INTAKE COMMENTS

Permit # 2305-015

Project Address: 5222 W. Mercer Way

Scope of Work: ADU above garage

SITE PLAN  
 ADU DESIGN FOR ELAINE BERRYMAN  
 5222 WEST MERCER WAY  
 MERCER ISLAND, WASHINGTON  
 BY TOHI SAITOS 206-854-8120  
 A1

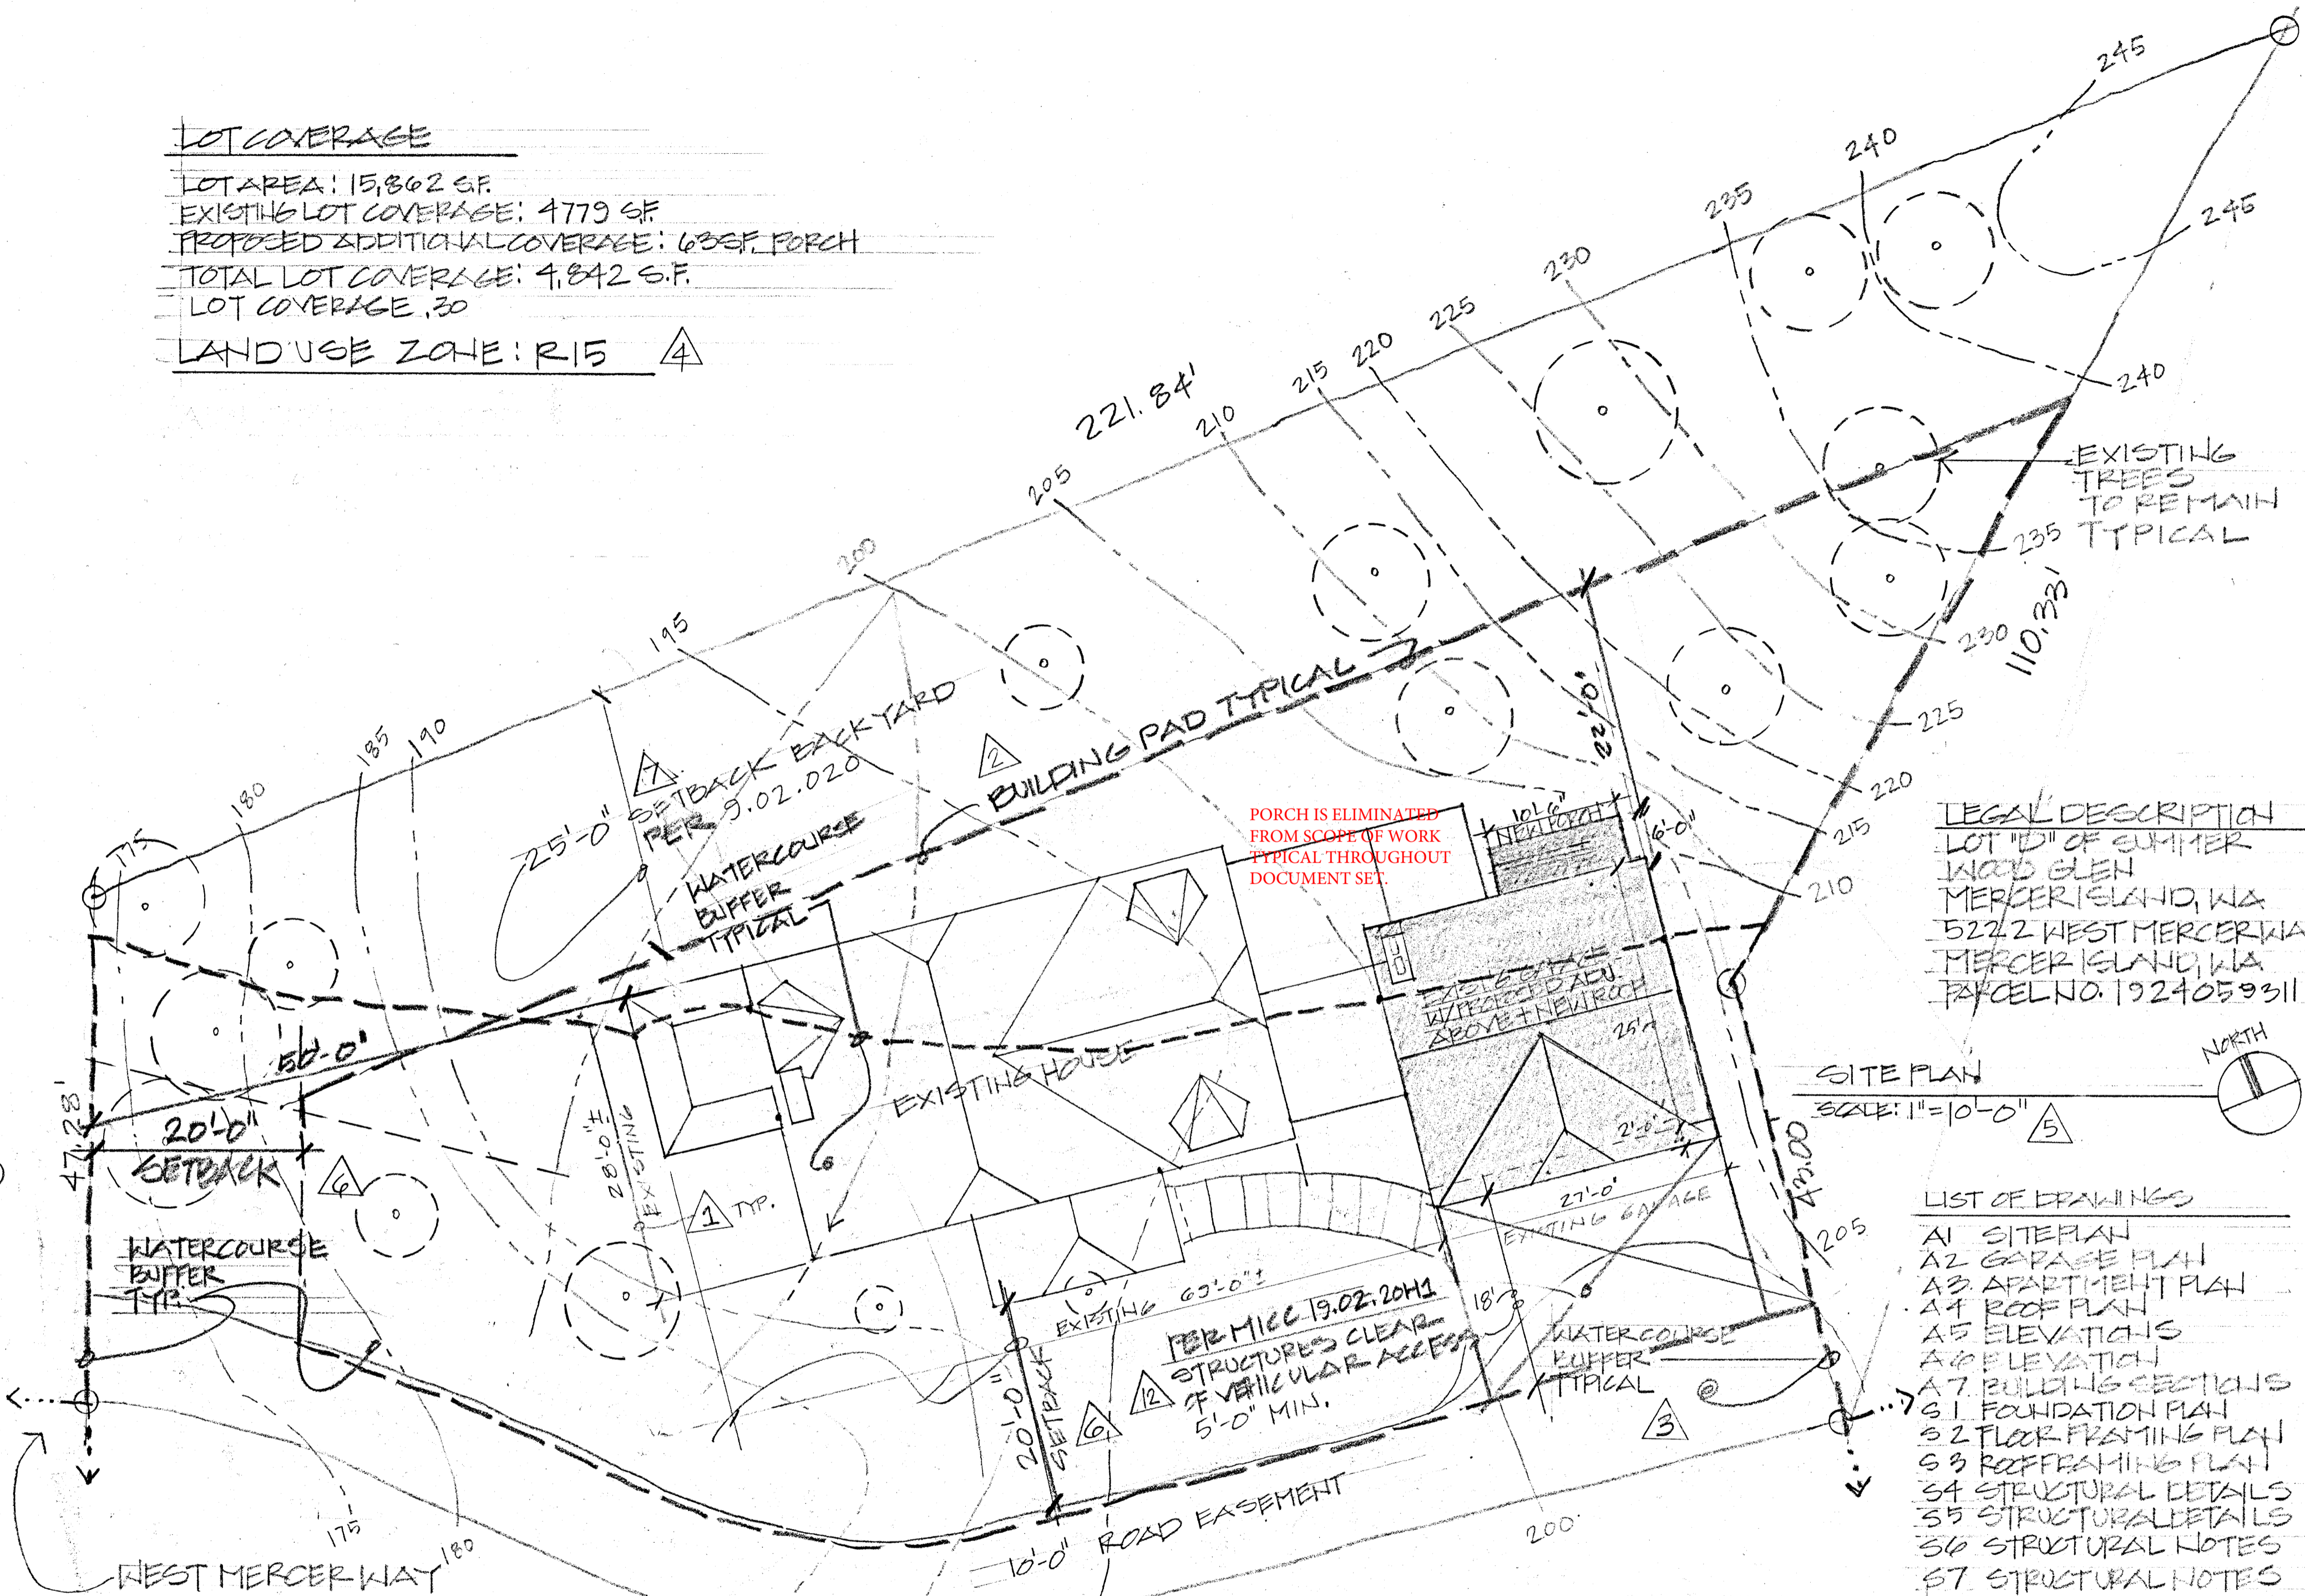
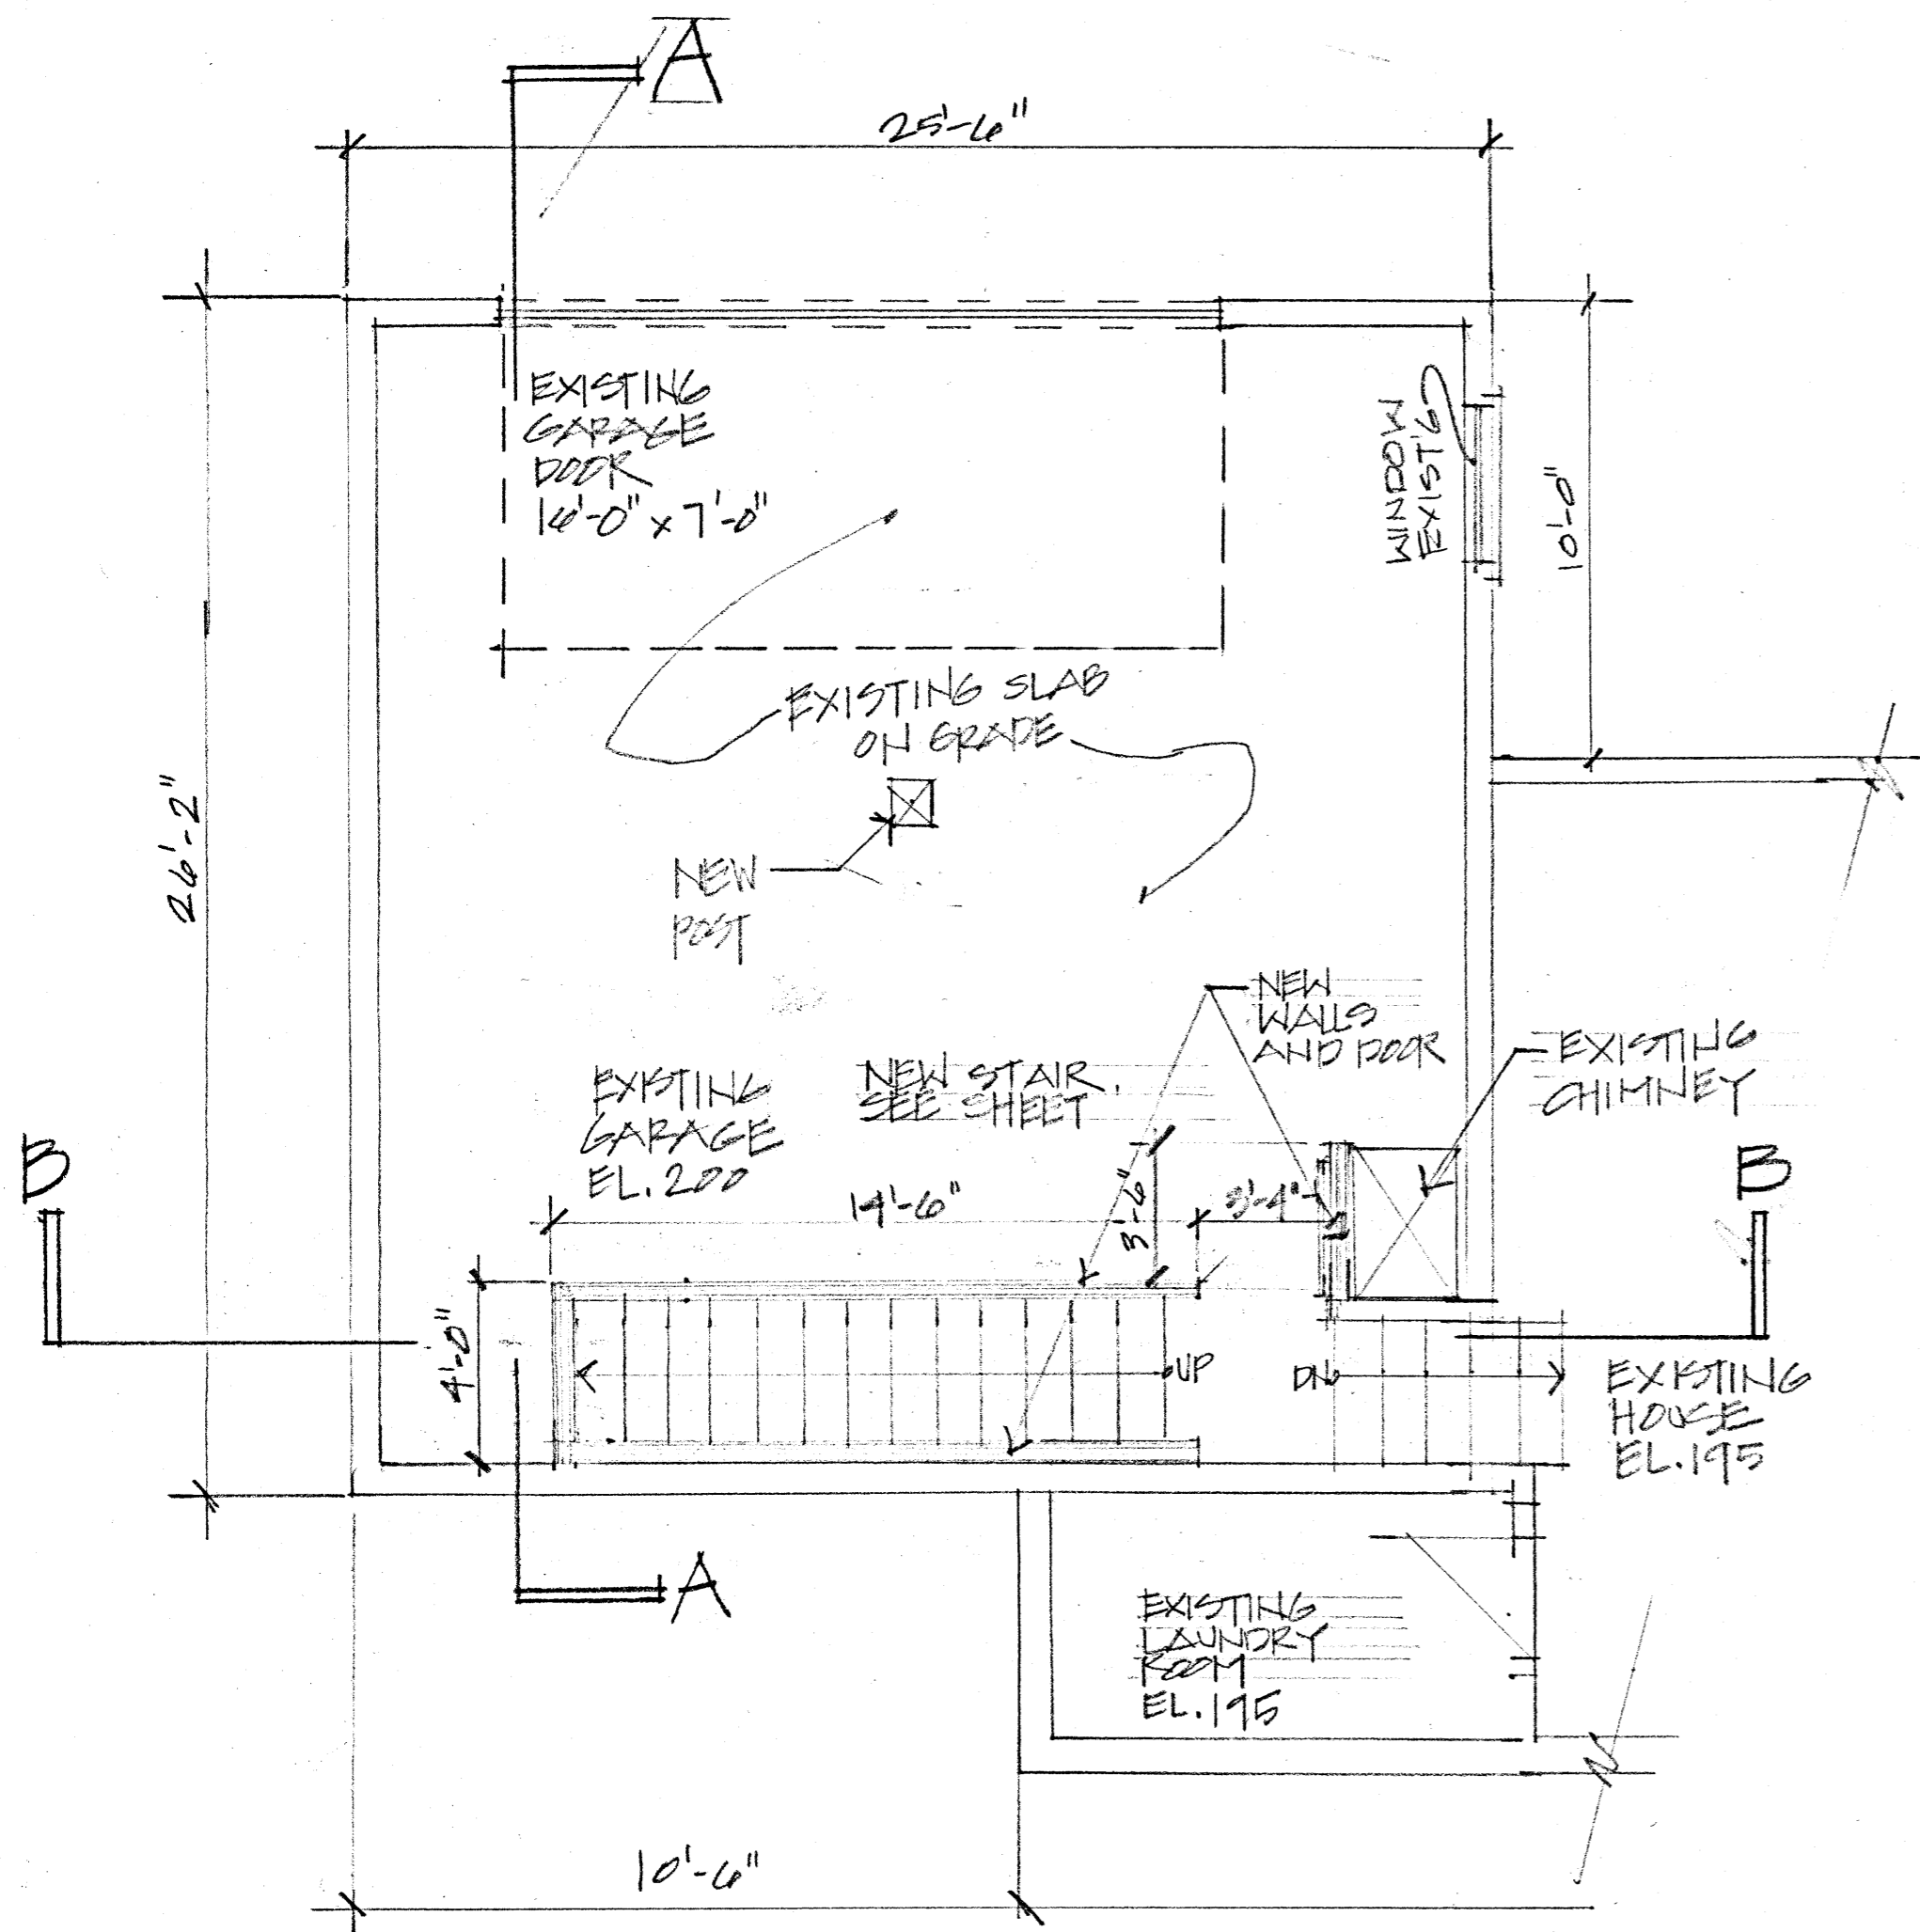
Indicate Building Dimensions :

Indicate Building Pad:

Indicate Critical Areas and Buffers (wetland, watercourse, steep slope):

Provide Land use Zone (R8,r,9.6,12,15):

Provide a Site plan to Scale:

Indicate yard setbacks (minimum distance from structures to property lines):

60-foot buffer of a mapped Type NP watercourse

The proposed ADU is located within the watercourse buffer, as well as within mapped geologically hazardous areas.

A Critical Area Review will be required for any addition outside of existing building footprints (including the proposed deck and any second story cantilevers). If the additions do not extend closer to the watercourse than the existing building and if the addition measures less than 200 square feet a Critical Area Review 1 will be required.

Please update the setbacks on the site plan as follows:

- The 20-foot front yard setback must be measured from West Mercer Way.

- The 25-foot rear yard setback must be opposite the front yard, so it would be measured from the east property lines.

- The side yards must add up to 17% of the lot width, with a minimum side yard setback depth of 33% of the total side yard depth.

- Please also show the 5-foot setback from the edge of the access easement in accordance with MICC 19.02.20(H)(1)

NOTE 1 on Site Drawing

NOTE 2 on Site Drawing

Note 3 on Site Plan

Note 4 on Site Plan

Note 5 on Site Plan

Note 6 Site Plan

Note 4 on Site Plan

Since the proposed deck is outside of the watercourse buffer and the additional cantilevered floor space is within the original footprint of the existing structure and less than 200 s.f., a Critical Area Review 1 is required.

Indicated on Site Plan

Indicated on Site Plan per:

Indicated on Site Plan

Indicated on Site Plan Note 8
